WEST SUSSEX COUNTY COUNCIL CONSULTATION

TO:	Arun District Council FAO: Hannah Kersley
FROM:	Highways, WSCC
DATE:	01/04/2025
LOCATION:	27 Argyle Road, Bognor Regis, PO21 1DZ
SUBJECT:	BR/249/24/PL Change of use from dwelling house (Class C3) to a 7-bed House in Multiple Occupation (HMO) (Sui Generis). This application is in CIL Zone 4 and is CIL Liable, as dwellings.
DATE OF SITE VISIT:	N/A
RECOMMENDATION:	Advice
S106 CONTRIBUTION TOTAL:	N/A

Bike Store Plan
1 : 50

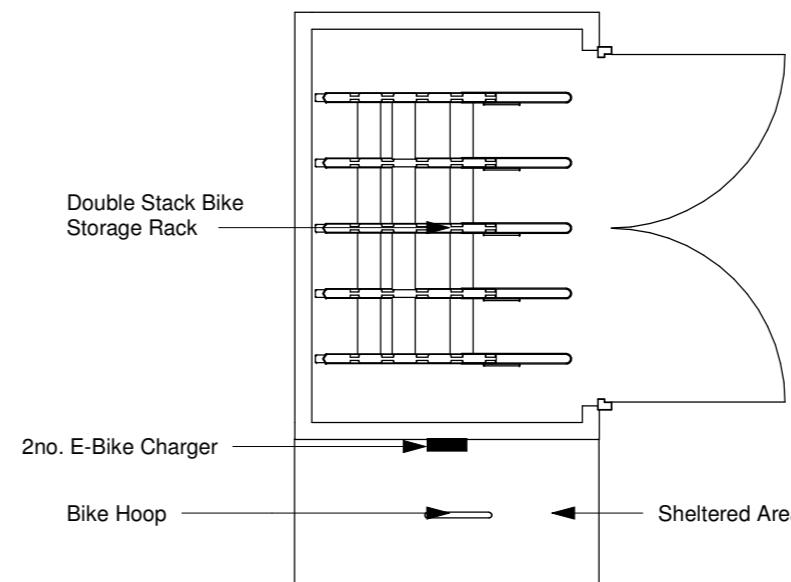
Weight is given to the fact the site is situated in a sustainable location within walking/cycle distance of local services and public transport links within Bognor Regis town centre. Provision for the storage of bicycles has been demonstrated to the rear of the site.
